From: Bavin, Ryan (NE) [Ryan.Bavin@naturalengland.org.uk]
Sent: 03 March 2011 09:53
To: Dewhurst, Gill
Cc: Evans, Ian (NE)
Subject: RE: Bats/birds and single wind turbine guidance

H20/0052/11

SITE PLAN - 1/1250

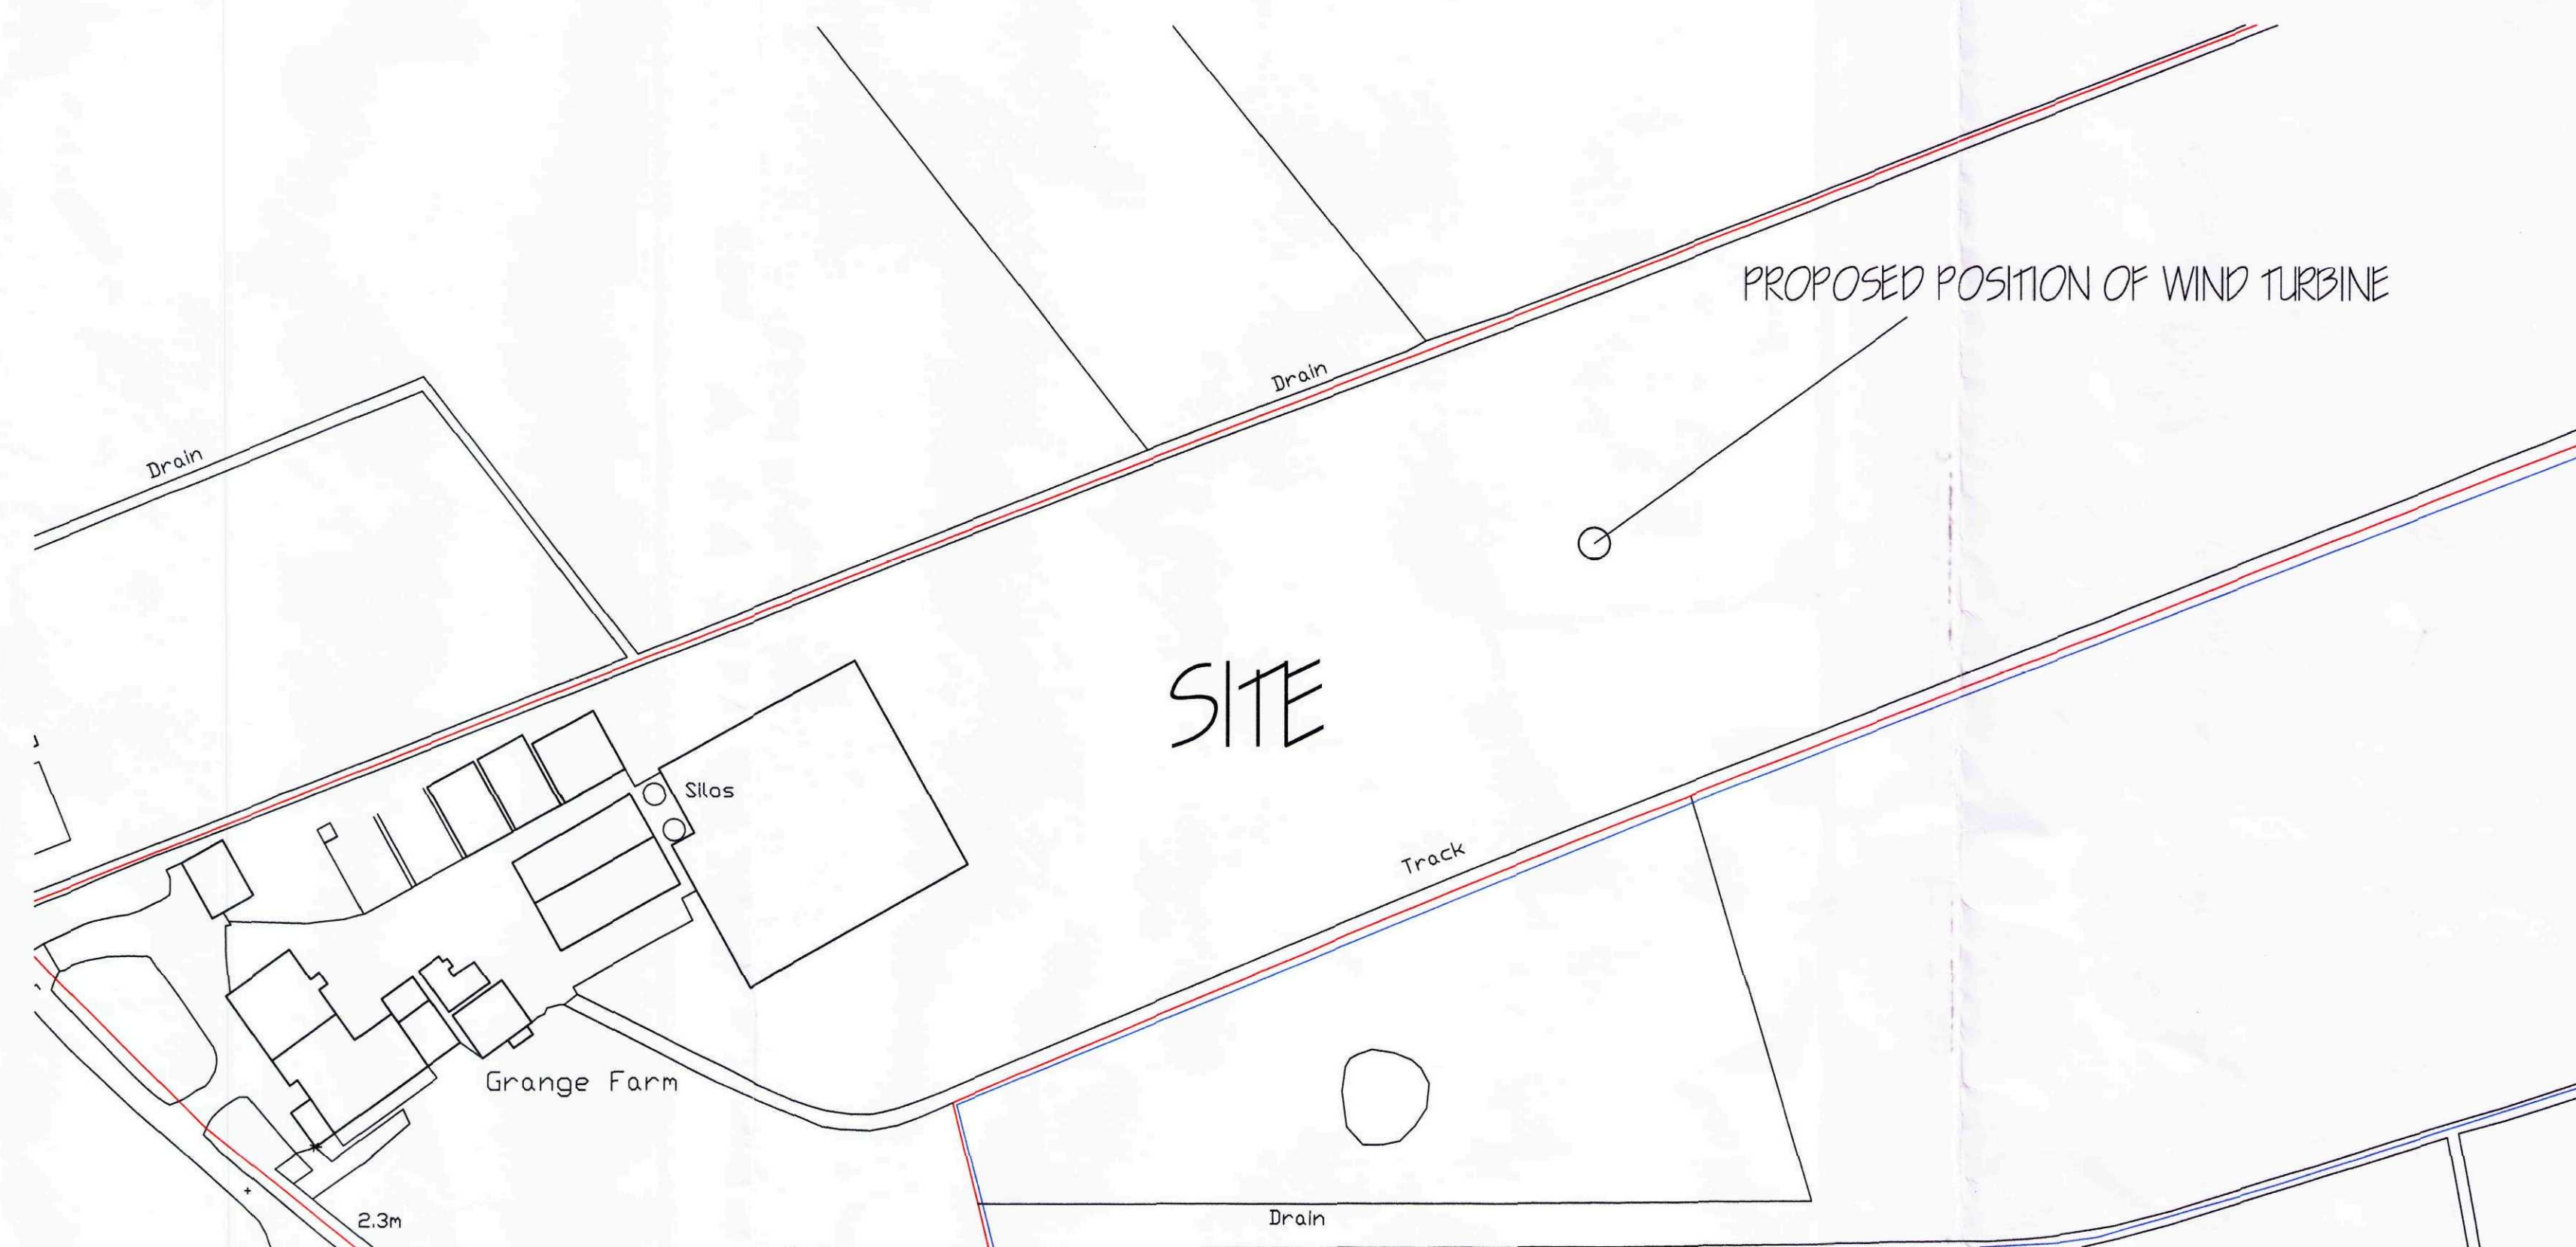
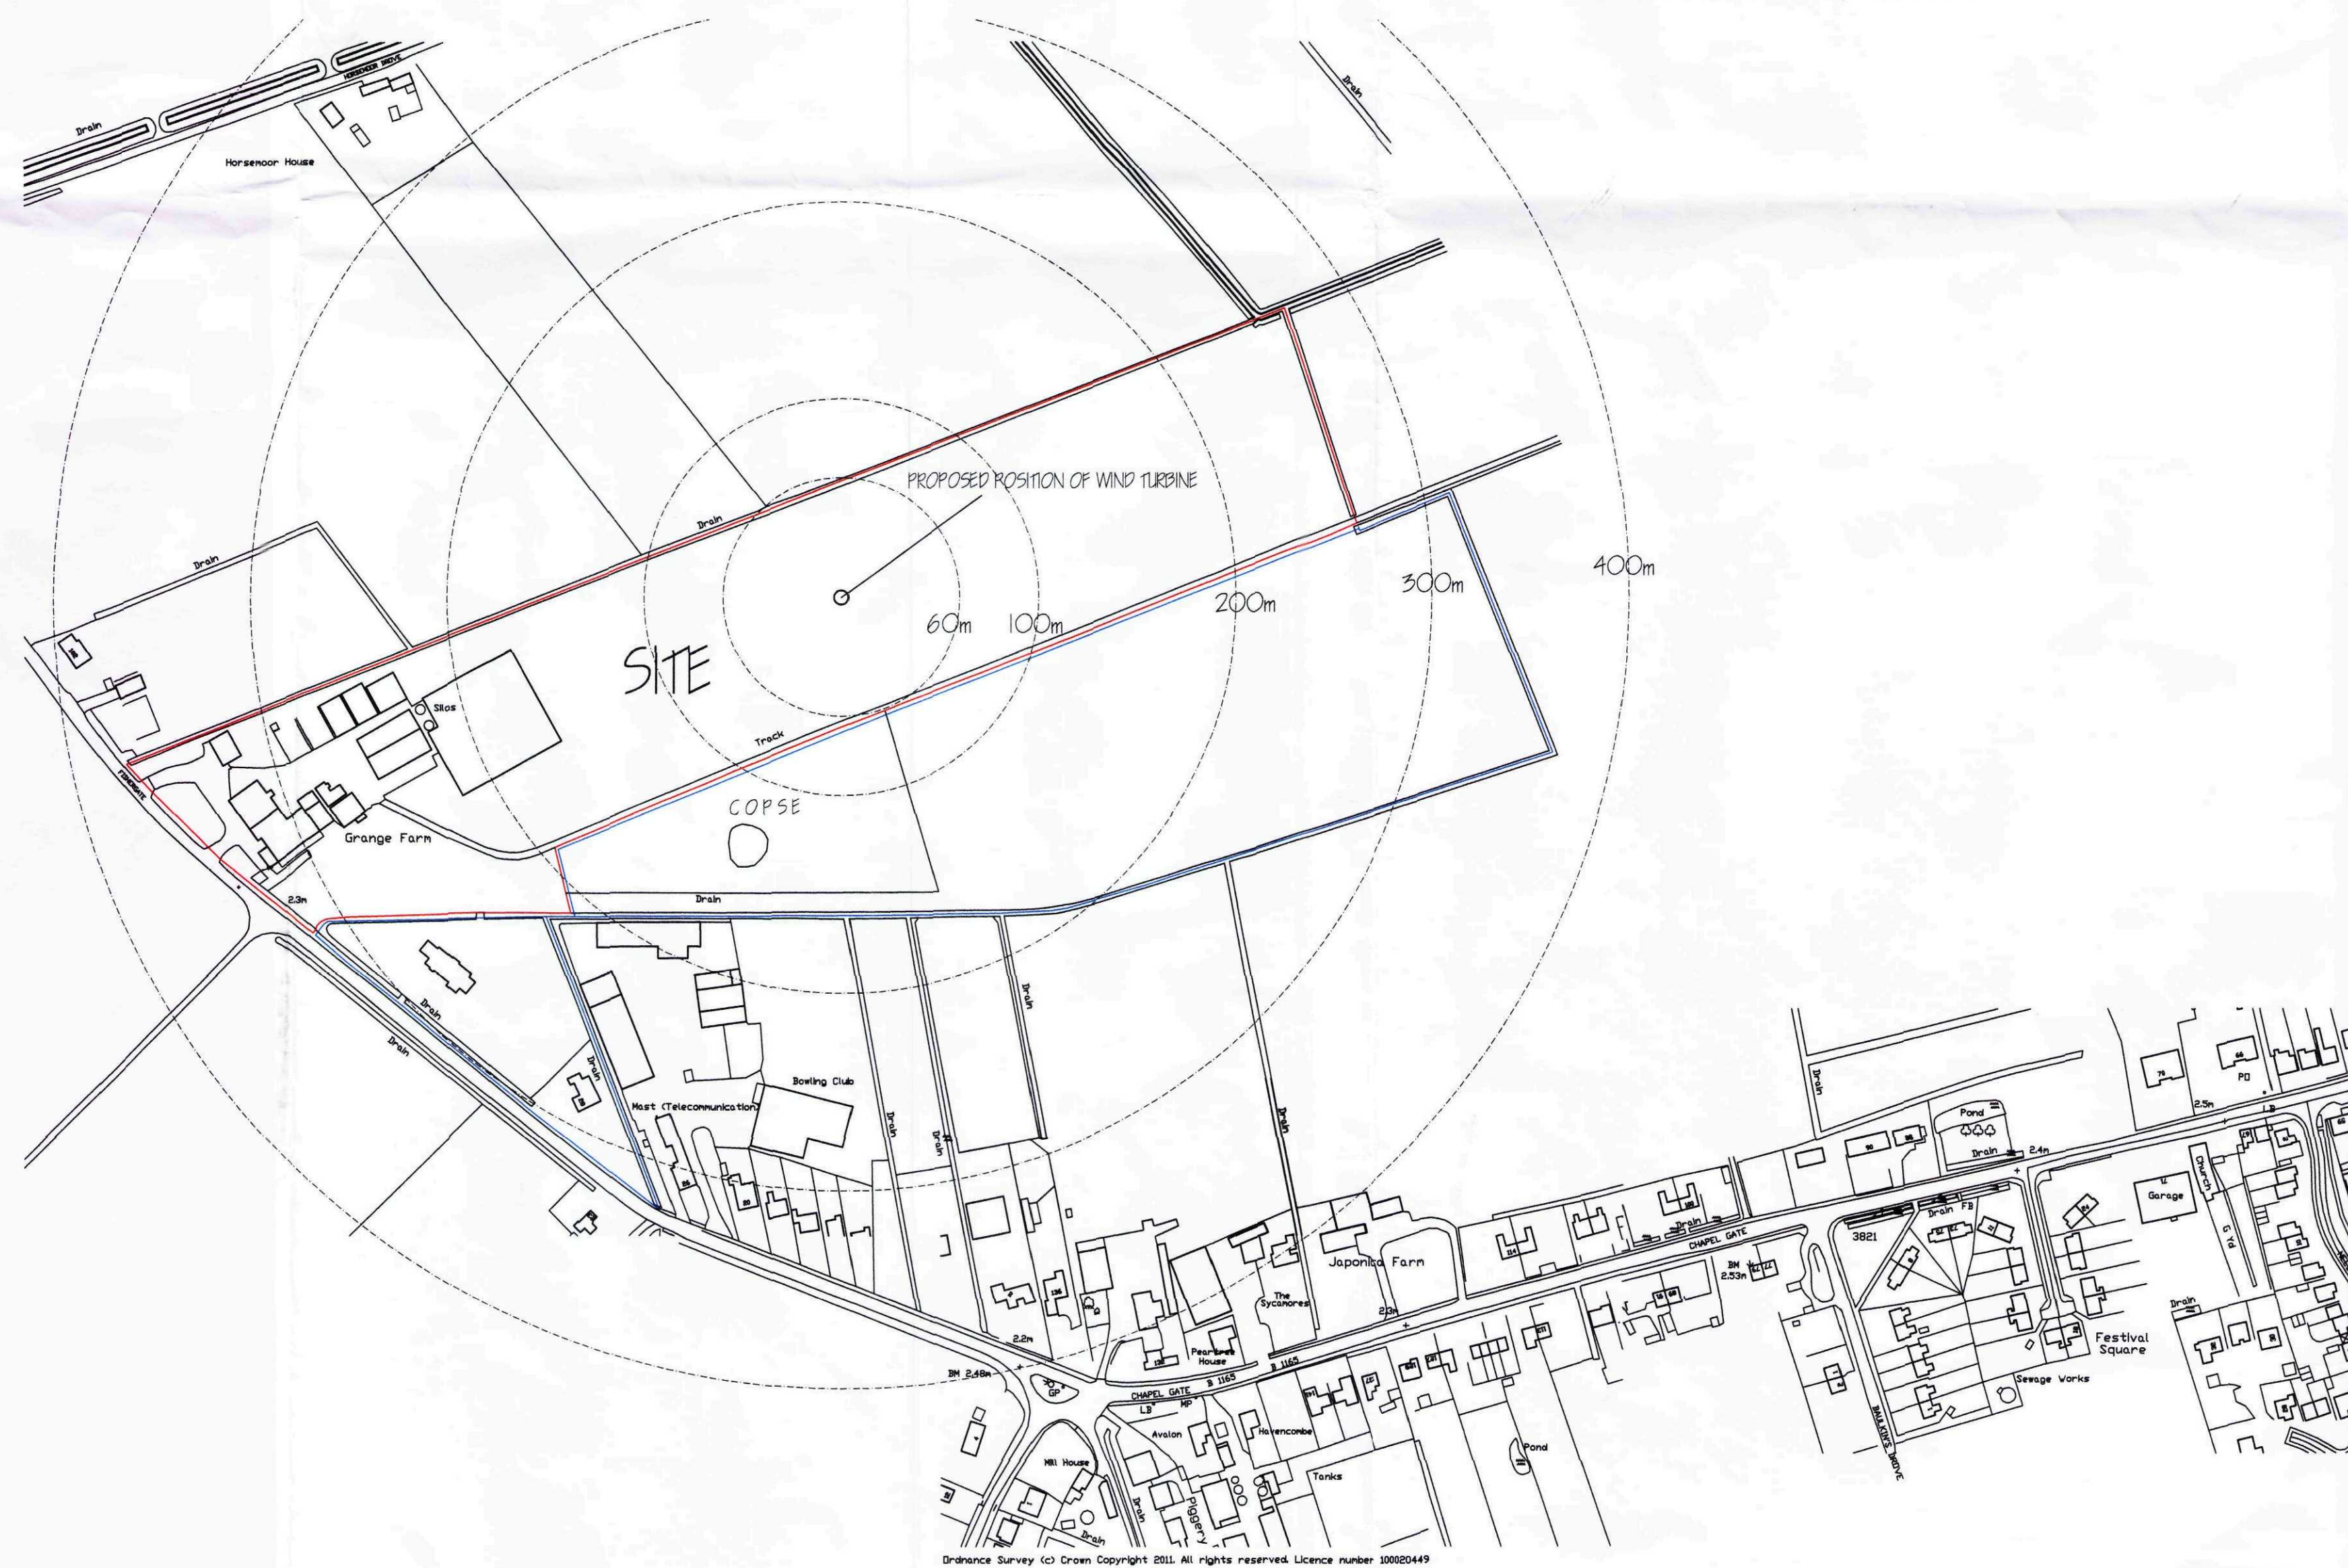
With regards to bats, as the guidance note explains, research has suggested that small turbines should be located at least 50m away from features of interest (e.g. – hedgerows, watercourses, known roost sites). As Sarah's email suggests, this already looks to be the case.

With regards to barn owls, the wind turbine should not be located close/adjacent to barns and farm buildings where barn owls are known to breed and roost.

Thanks for the information although I am unable to ascertain whether the bats and birds will be affected in this area as there are a lot of barns, farm buildings and trees relatively close.

With reference to the above application please find attached the Bat and Bird Guidelines for Wind Turbines received from Natural England. After speaking to Ryan and reading the information I beleive that a report is not required due to the the proposed wind turbine being more that 50m away from dykes/hedgerows and buildings. Also we are not taking away any trees / structures to
